**Application no: 23/01493/REM**

**Location:** Proposed Himley Village North West Bicester, Middleton Stoney Road, Bicester

### Transport Schedule

TITLE
PHASE 1B BUS TRACKING

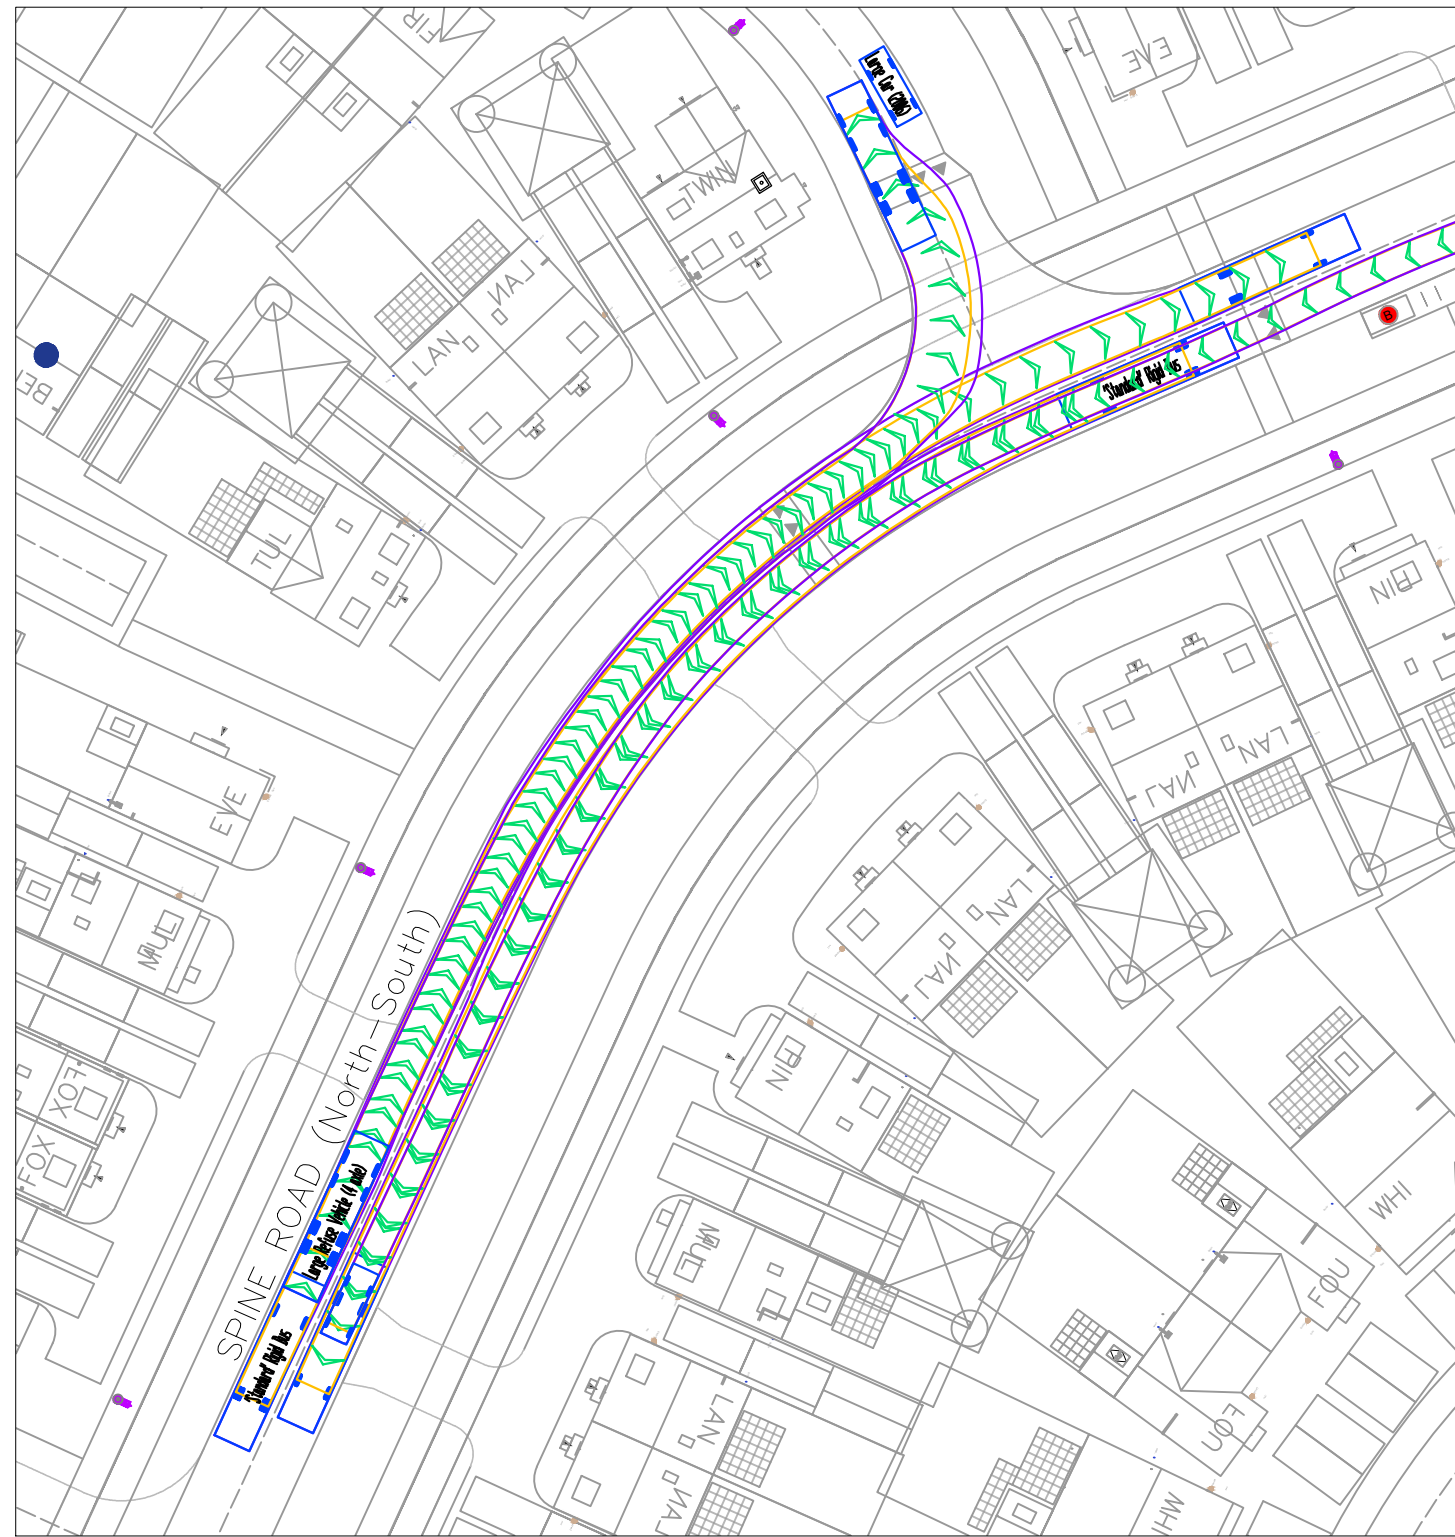
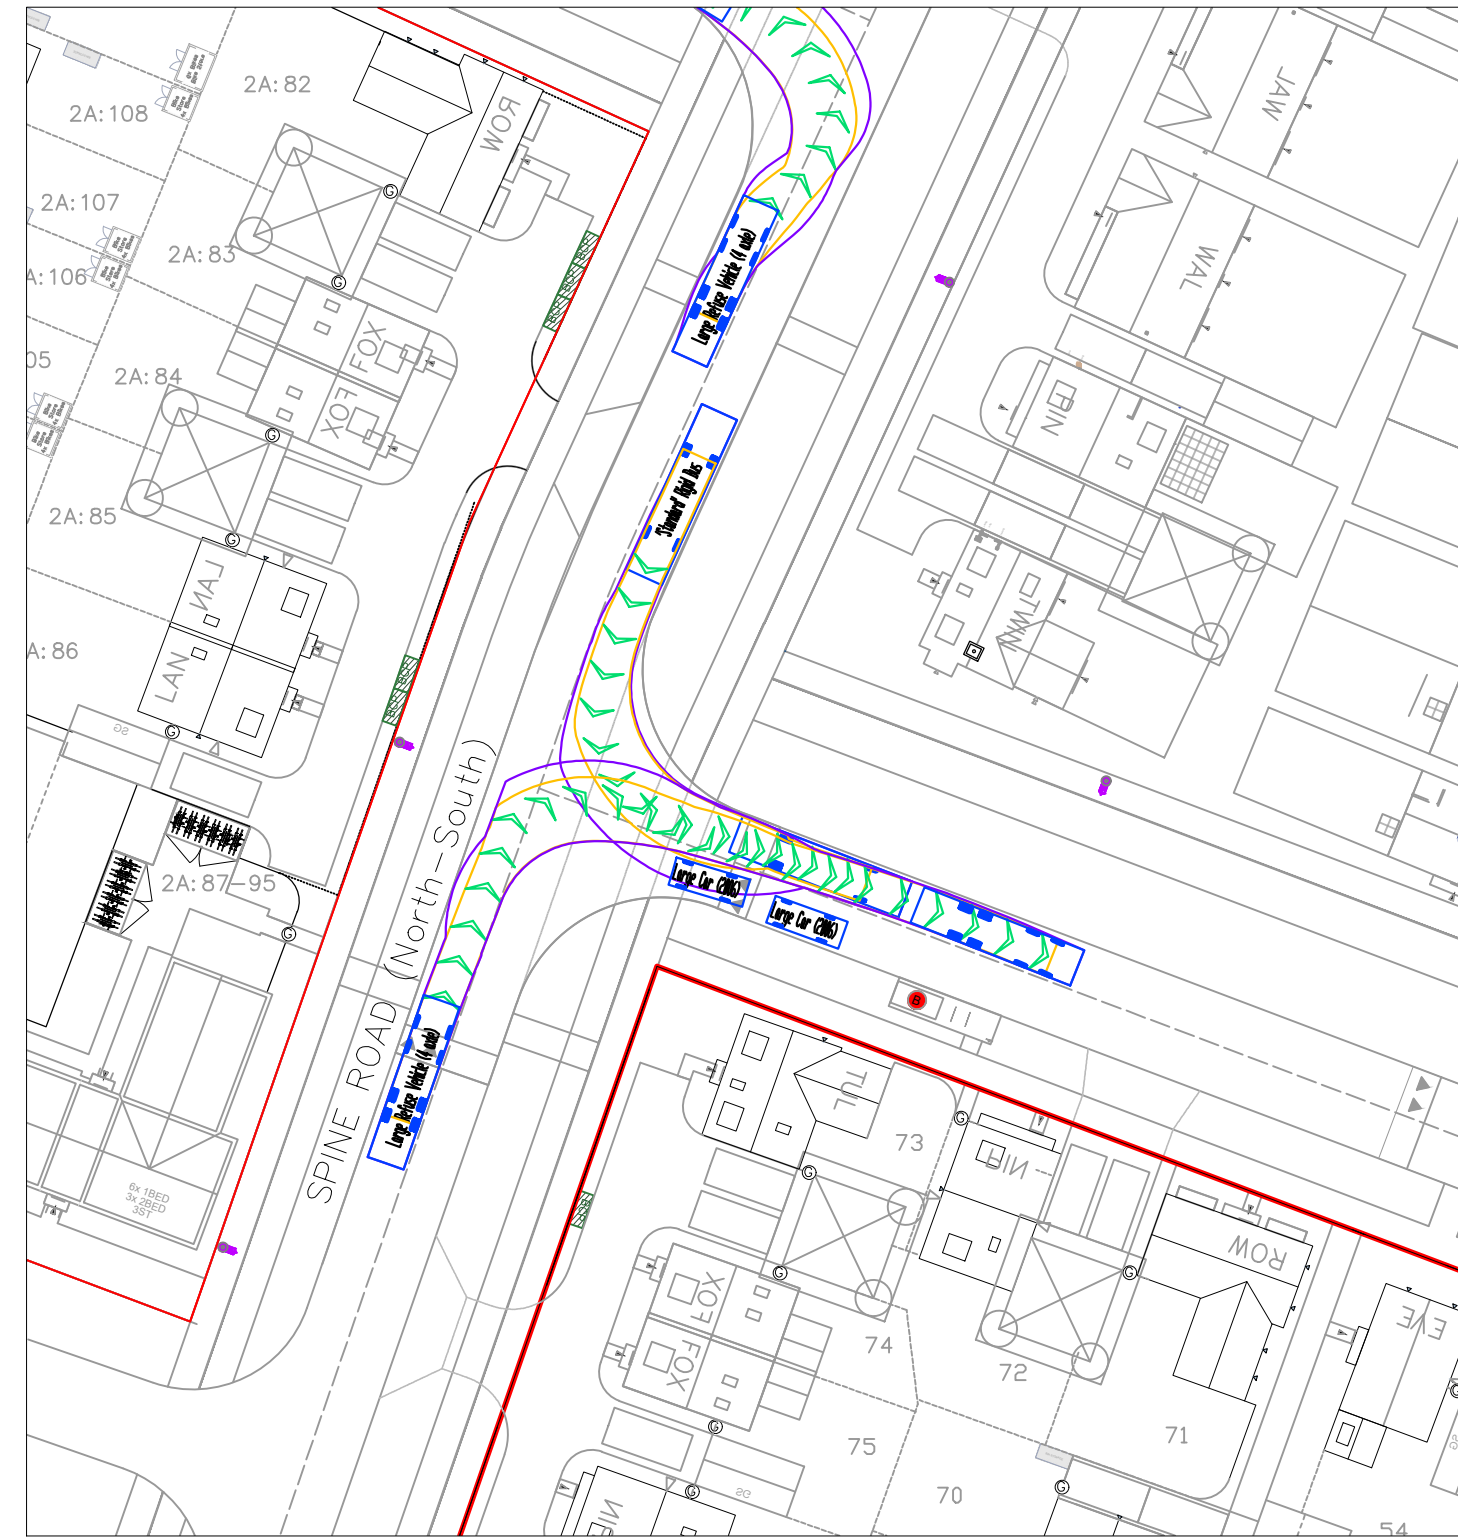
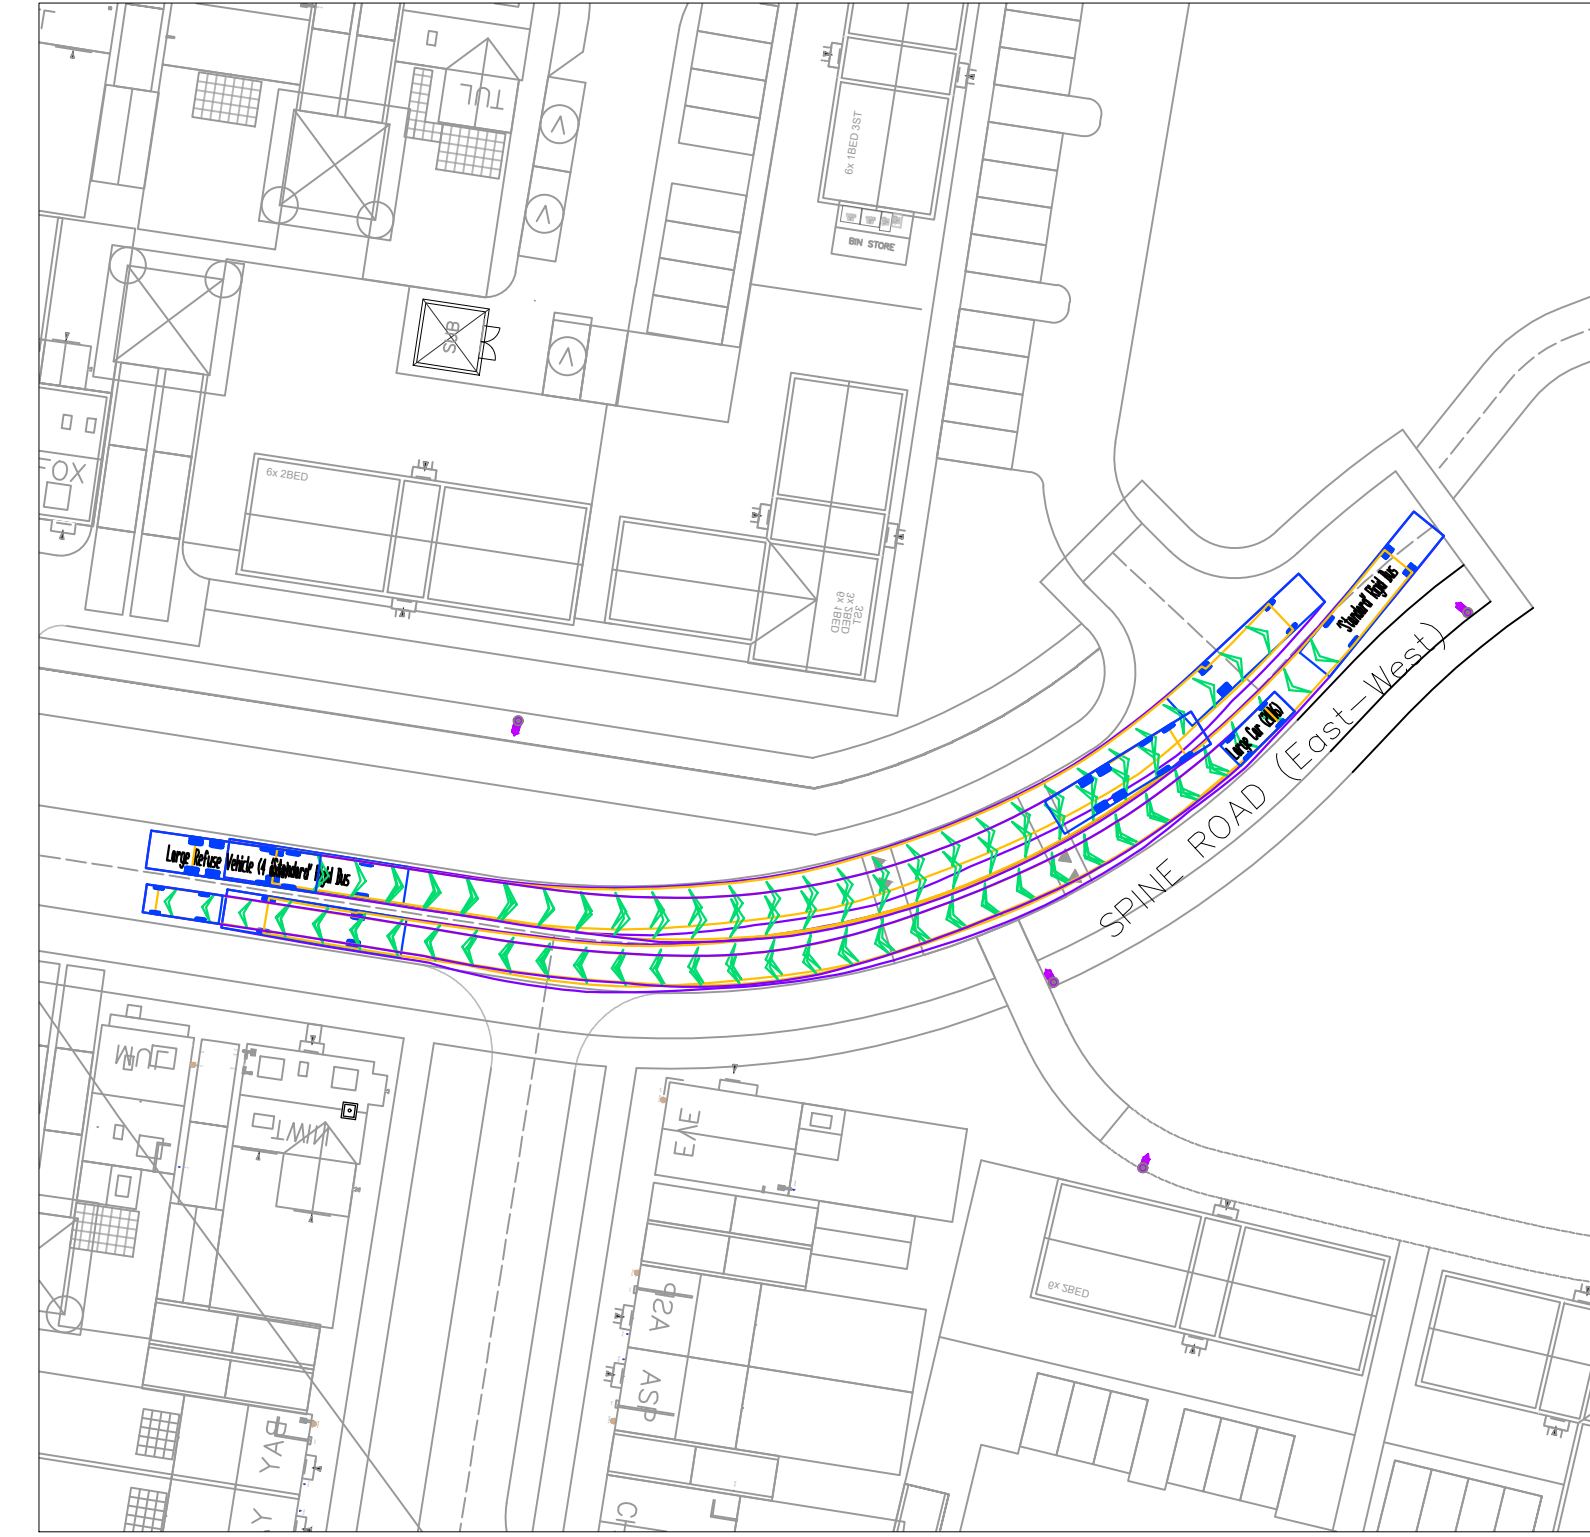
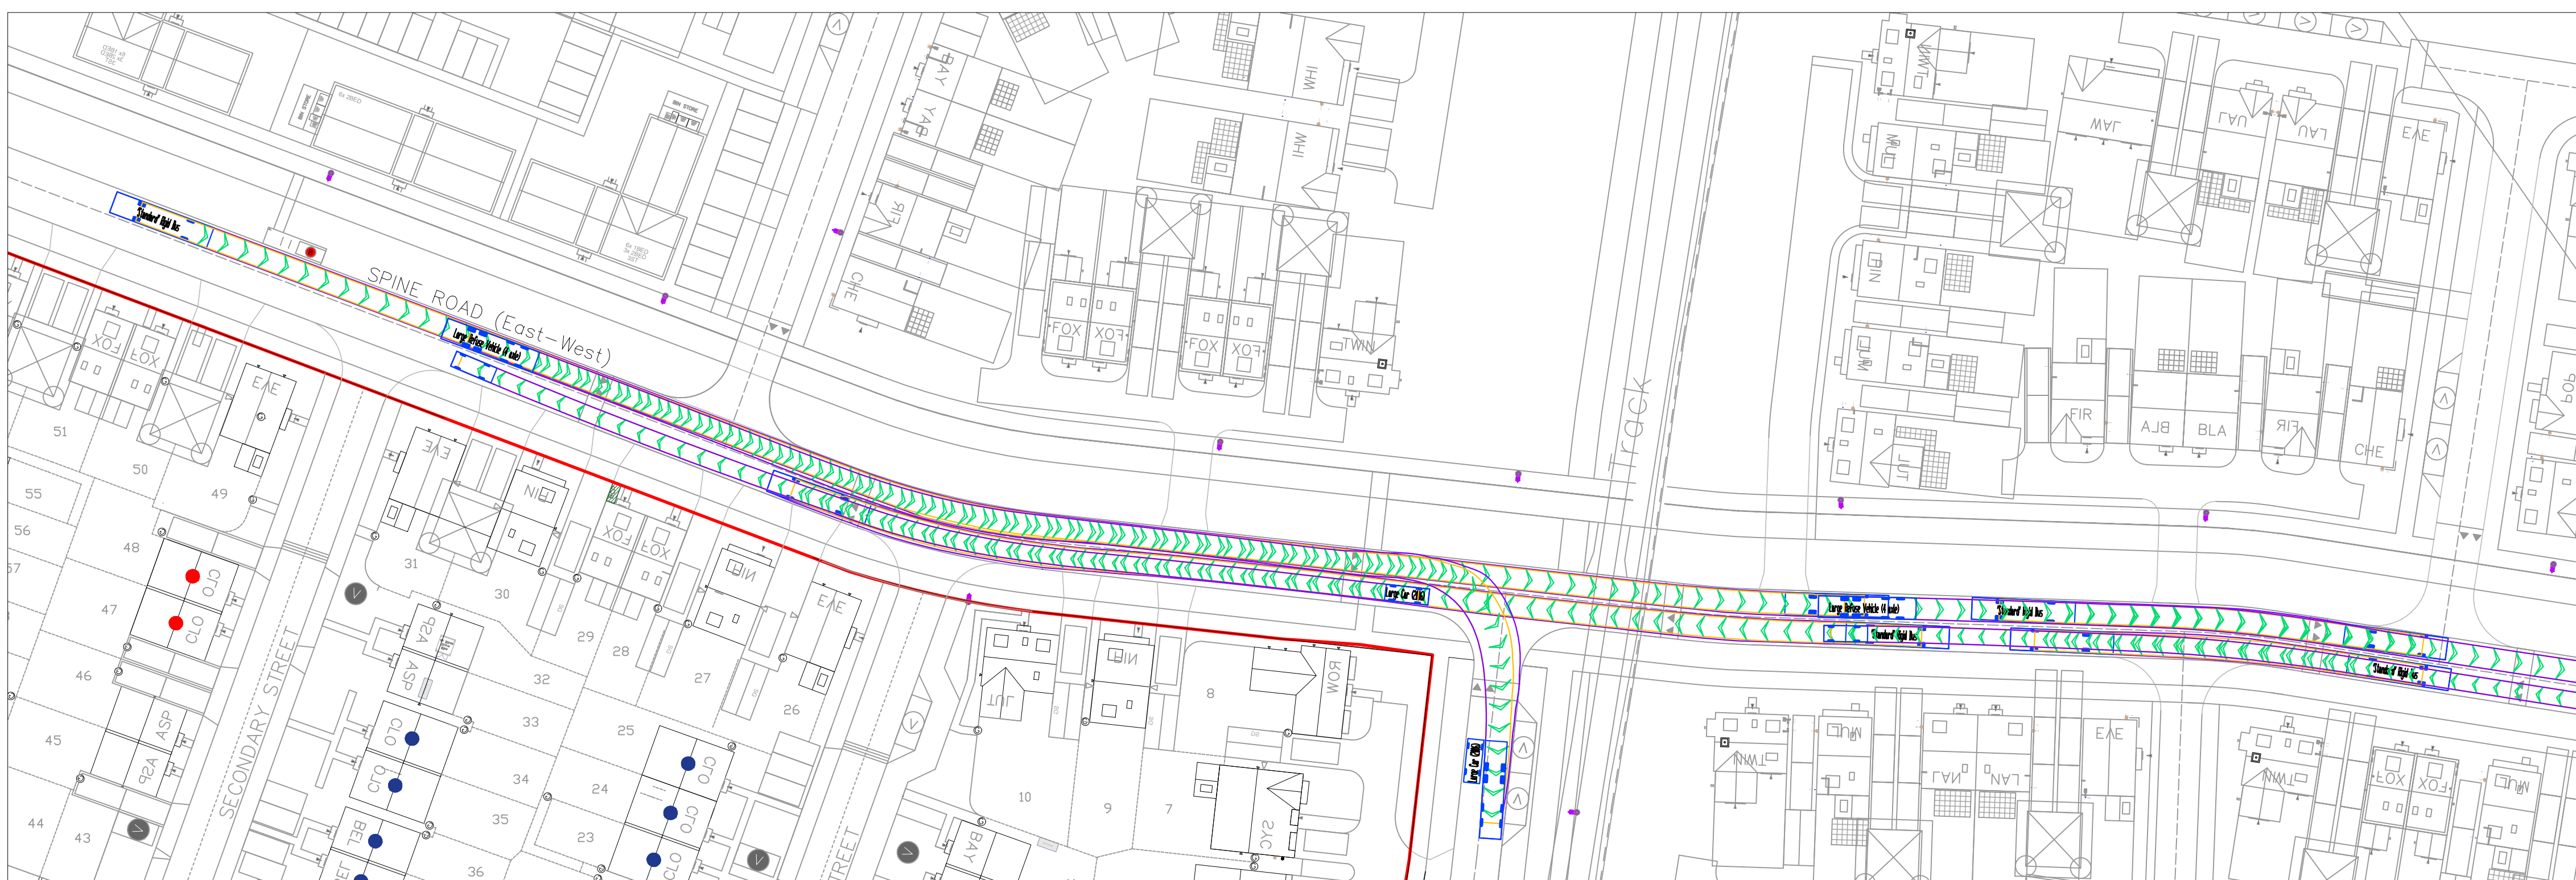
The temporary bus turning heads are not acceptable as it will require buses reversing over the raised cycle crossings which is considered a safety issue. In addition, all wheels will need to face forward and not be at an angle at the turn. Specifically designated independent turning heads should be constructed for buses to be able to turn.

OCC Highways agree that we won't build a raised table for the time being and have bollards and signs for a temporary arrangement for a bus. Have a condition attached to the RM approval to say once turning head is not needed the raised table will be constructed.

OCC Highways agree that the raised table temporarily won't be built and will have bollards and signs. Like with the East West Spine Road a condition will be attached to the RM approval to say once turning head is not needed the raised table will be constructed.
